## ATTACHMENT 1 – Department’s Response to Submission review comments

In order to finalise the Department’s assessment, additional information is required including but not limited to the following:

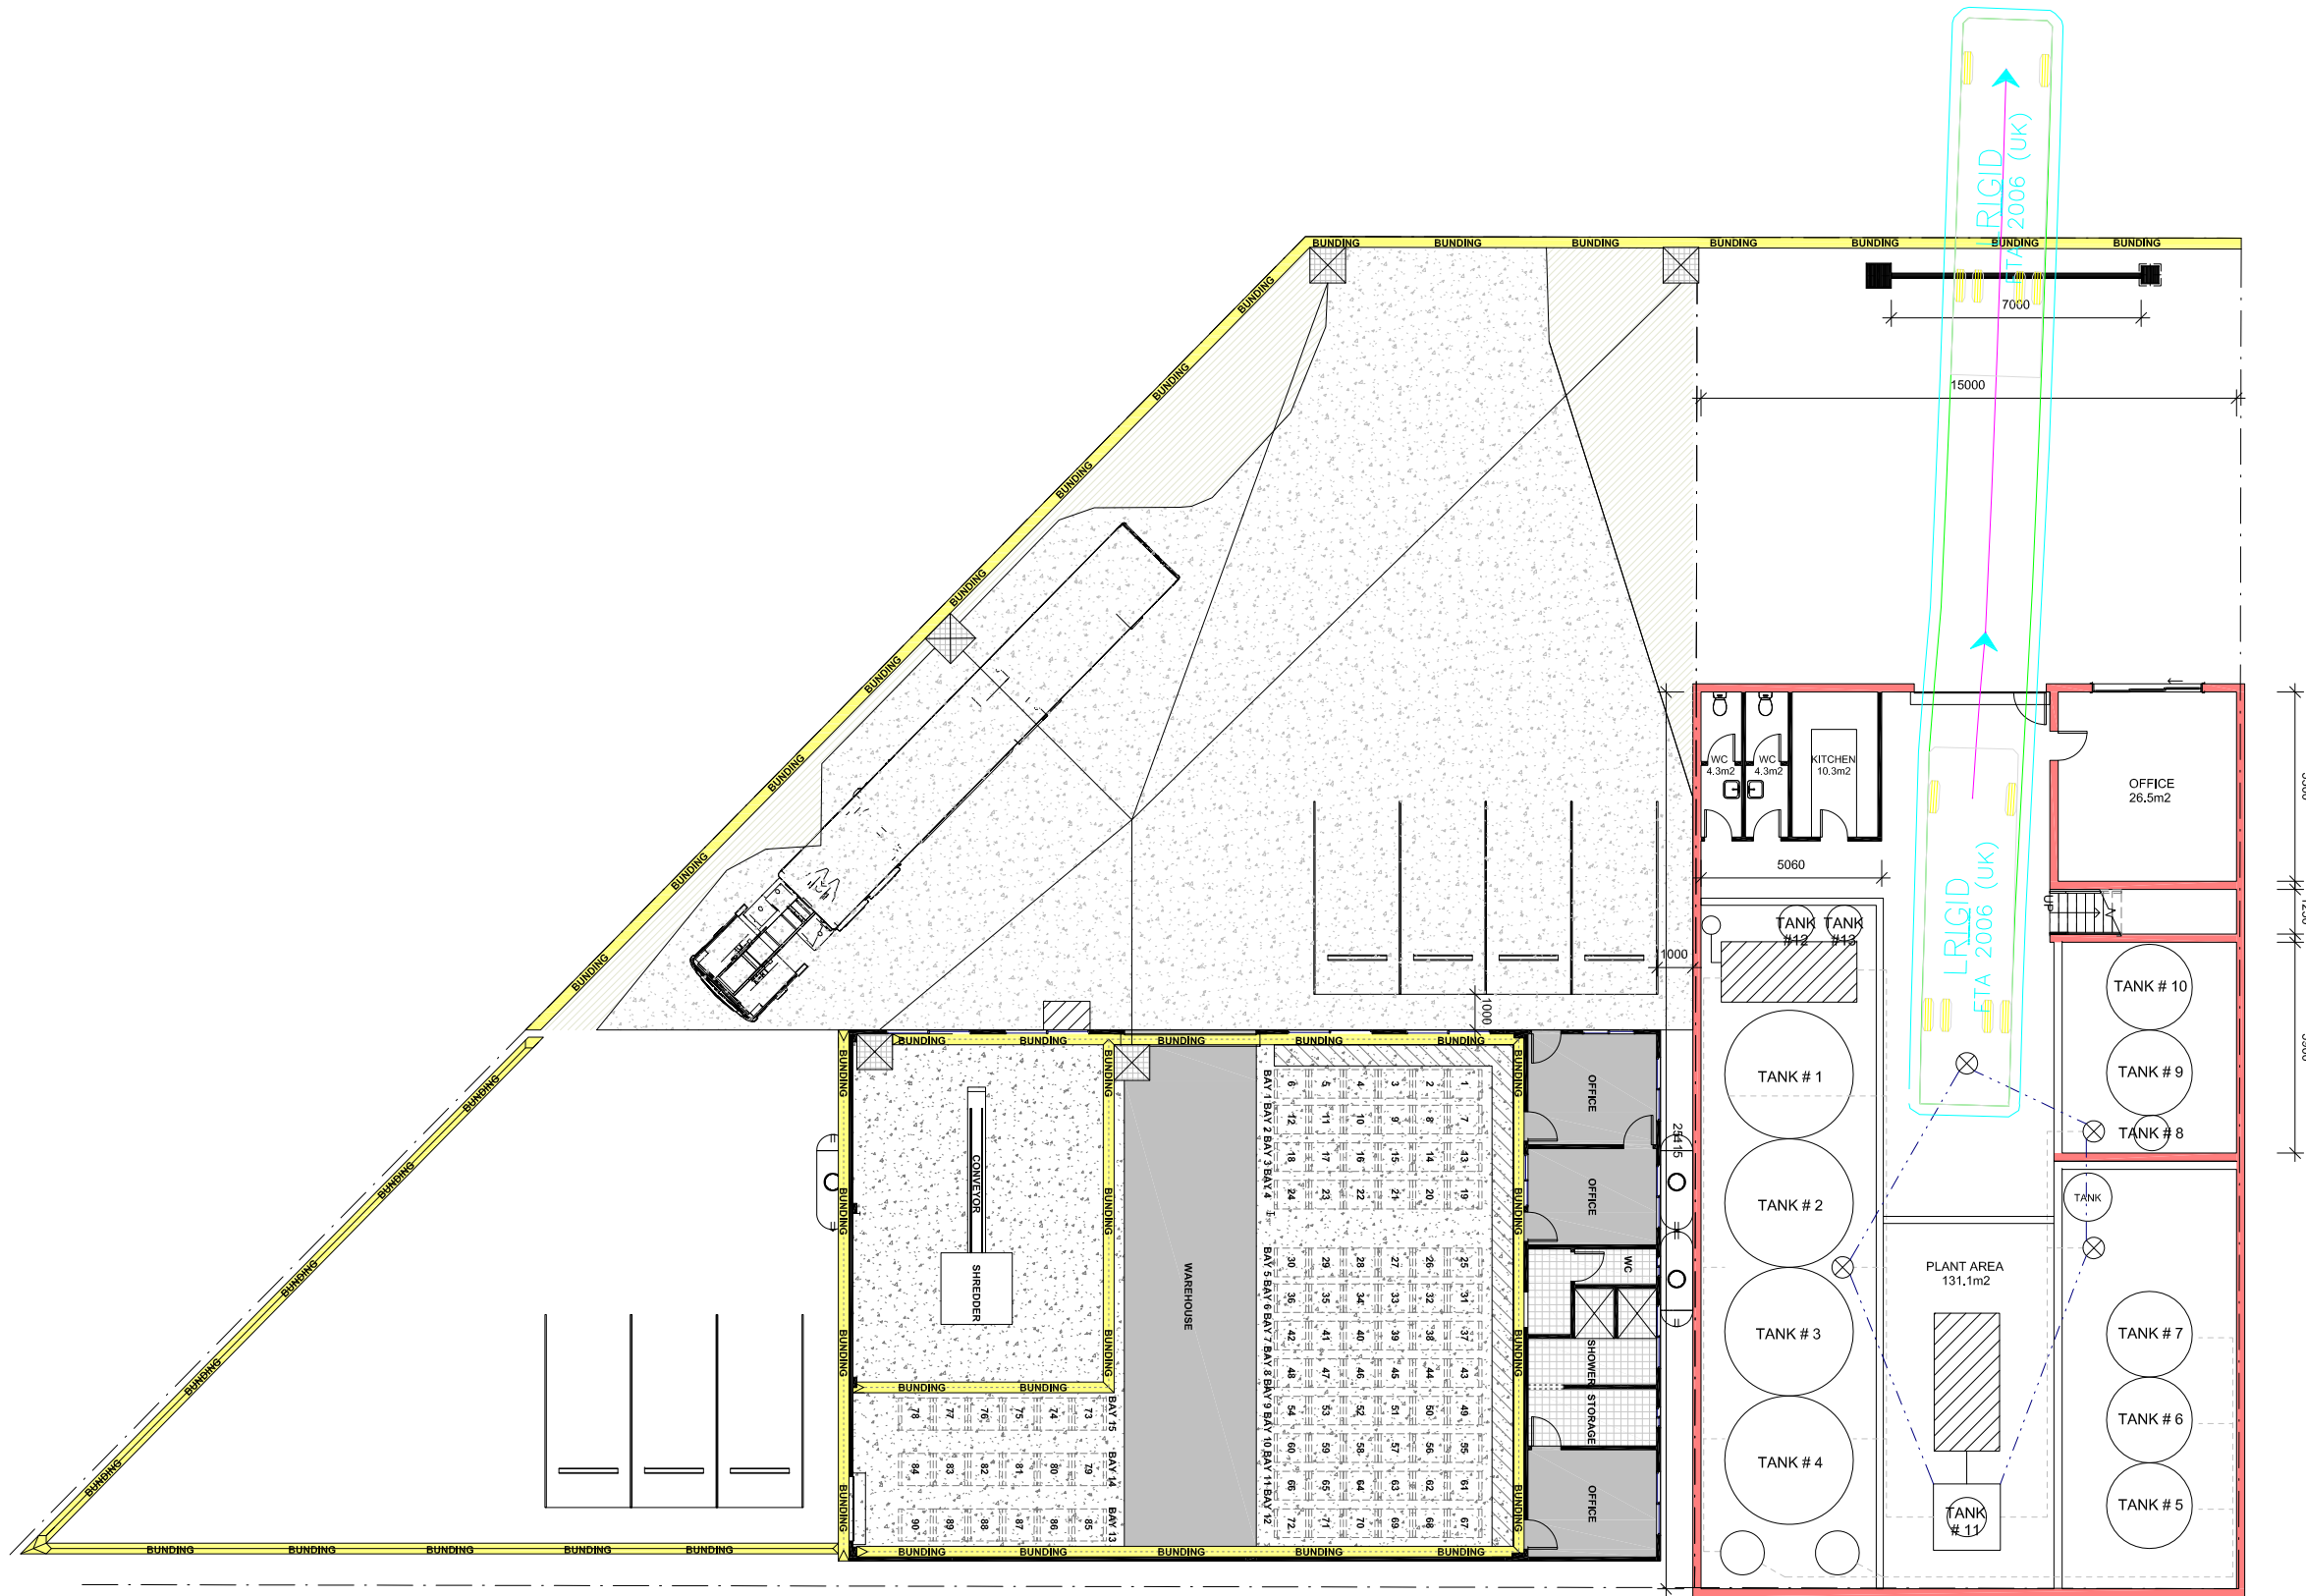
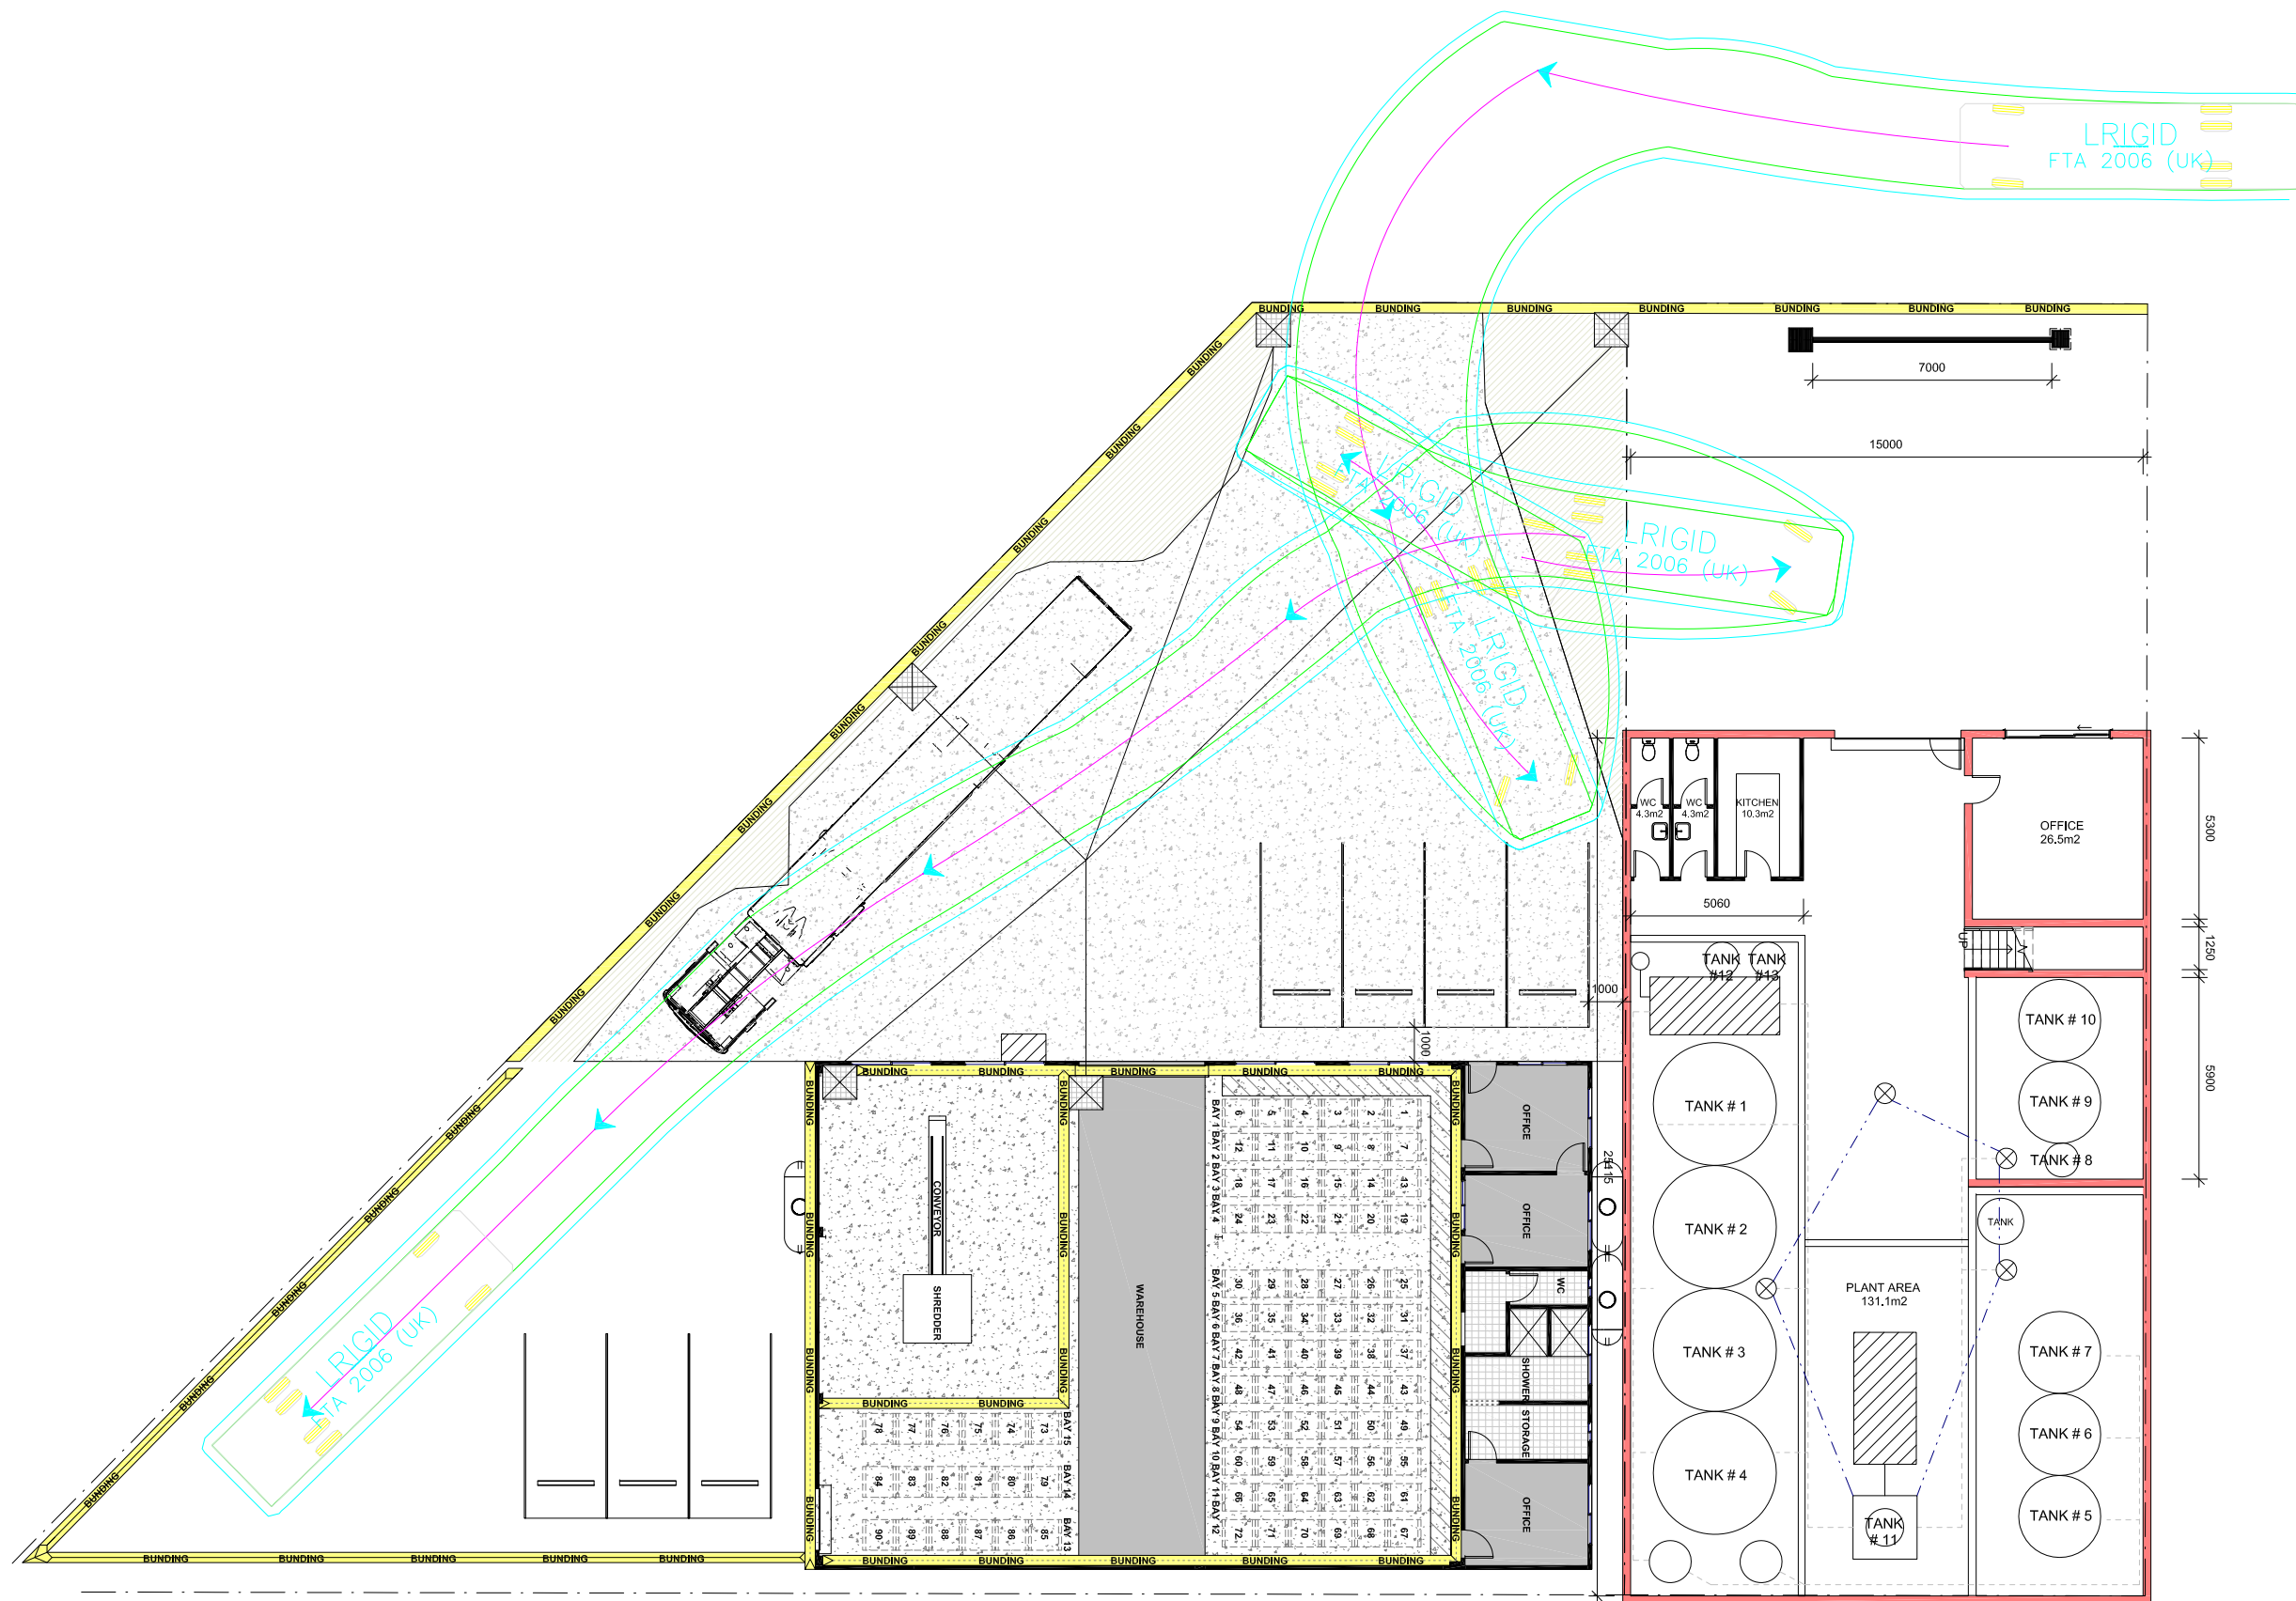
- The vehicle and trucks registration provided in Attachment 8 of the revised EIS lists a site vehicle which is 11.5 metres (m) in length, however swept paths provided have only been provided for 10 m trucks. For consideration of potential future delivery vehicles and to be consistent with Australian Standards, swept paths should be provided for 12.5 m trucks. Please update.

- The Department has previously requested for the Applicant to further consult with Council to resolve truck manoeuvrability issues at the site. The RtS does not provide sufficient evidence to indicate that internal swept path movements have been satisfactorily resolved with Council. Trucks are still required to be undertake a four-point turn and reverse into Council land which has been identified as being unsatisfactory by Council, whereby manoeuvring should be limited to a 3-point turn into the site. Please address.

- Council have further identified safety risk concerns associated with reverse manoeuvring on Council’s land. Vehicles are required to enter and leave the site in a forward direction. The Applicant has not resolved this issue.

- Update the swept path drawing to clearly demonstrate vehicle movements entering and leaving both 14 and 16 Kiara Crescent.

- Council have identified that they would not support the proposed driveway widening and that the use of the driveway should be for access only, and not for manoeuvring. It is further noted that the proposed widening of the driveway at 16 Kiara Crescent to allow for greater room for vehicle turning also contradicts with Council's request for all vehicles to manoeuvre within the site itself. Please address.
